Our ref: SDNP/17/SDJAUT
Arun District Council ref: A/99/17/OUT

3 August 2017

Outline planning application for 175 dwellings at land south of Water Lane, Angmering

Plan illustrating Proposed Green Infrastructure
produced by David Jarvis, 2016. NTS.

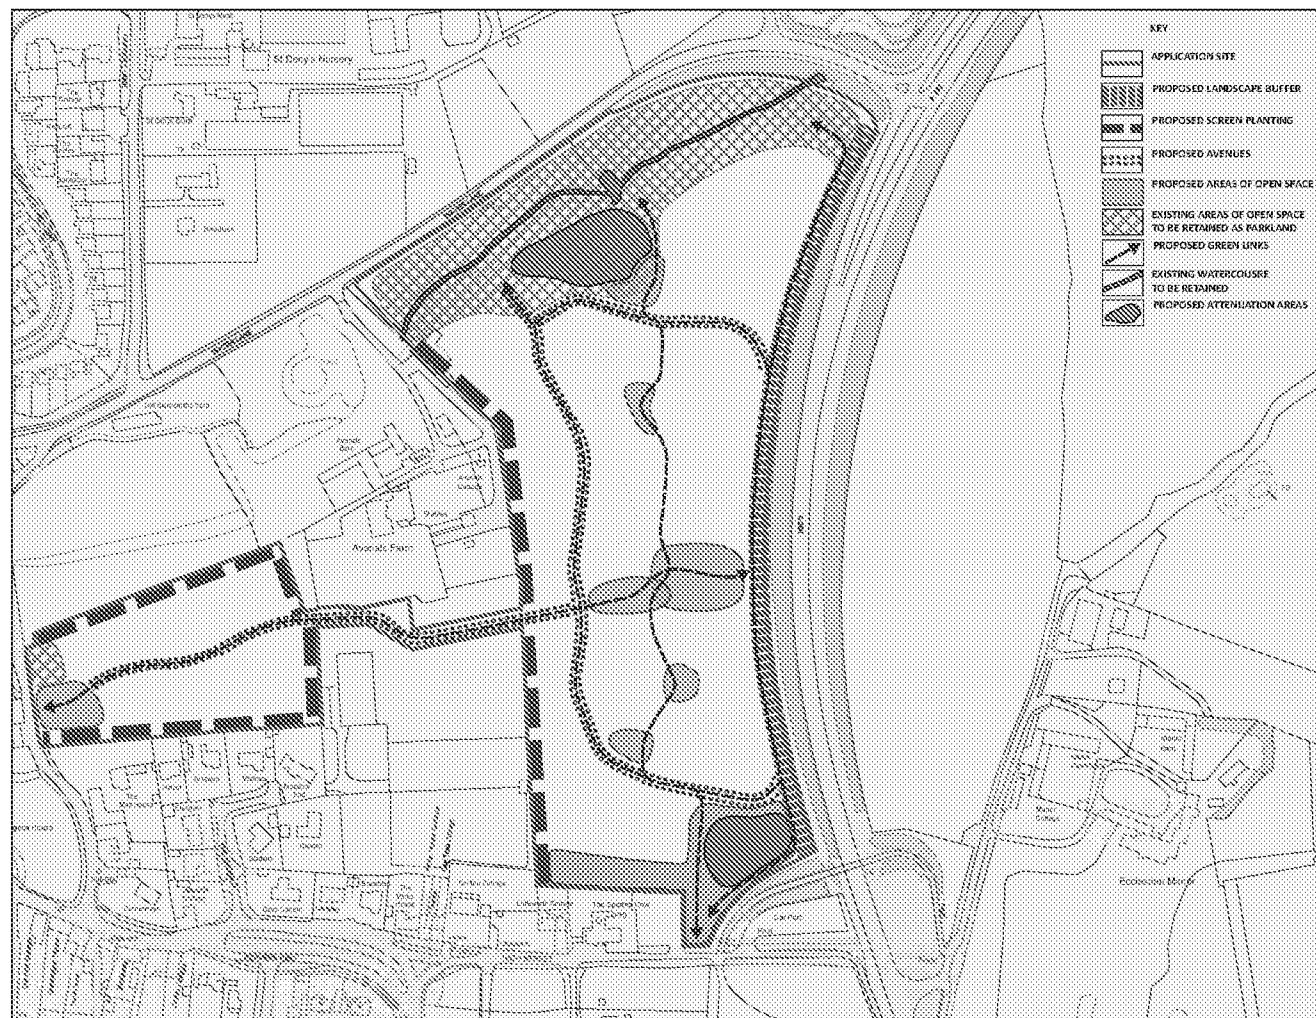
- The scheme does not appear to have been master planned using a landscape-led approach. This approach is crucial in sensitive landscapes such as this. It does not respect or respond to key landscape features on or close to the site, such as historic buildings, farmsteads, the watercourse and its function, key views, design, functional greenspace provision, historic boundaries.

- The site boundary itself appears to produce a disconnected scheme linked via a road, which, we suggest, serves to isolate green spaces as unusable pockets outside of the scheme.

- We would suggest the greenspaces within the site are insufficient in size and isolated to be able to produce any meaningful benefits for people or wildlife, other than the numerous play areas for children.

- The high density and 'inward-looking' layout and form of the development makes no attempt to respond to its landscape context or deal appropriately with the edge of the development to enable it to sit more comfortably within the landscape.

- Sustainable drainage (SuDS) does not appear to be integrated into the scheme and appears reliant upon two attenuation areas which the surface water will have to find its way to. Integrated vegetative SuDS is a much better way to achieve *in situ* drainage alongside internal green infrastructure requirements.

- A lack of green infrastructure through the scheme to help to integrate it into the landscape and create green corridors for wildlife inside and outside of the National Park.
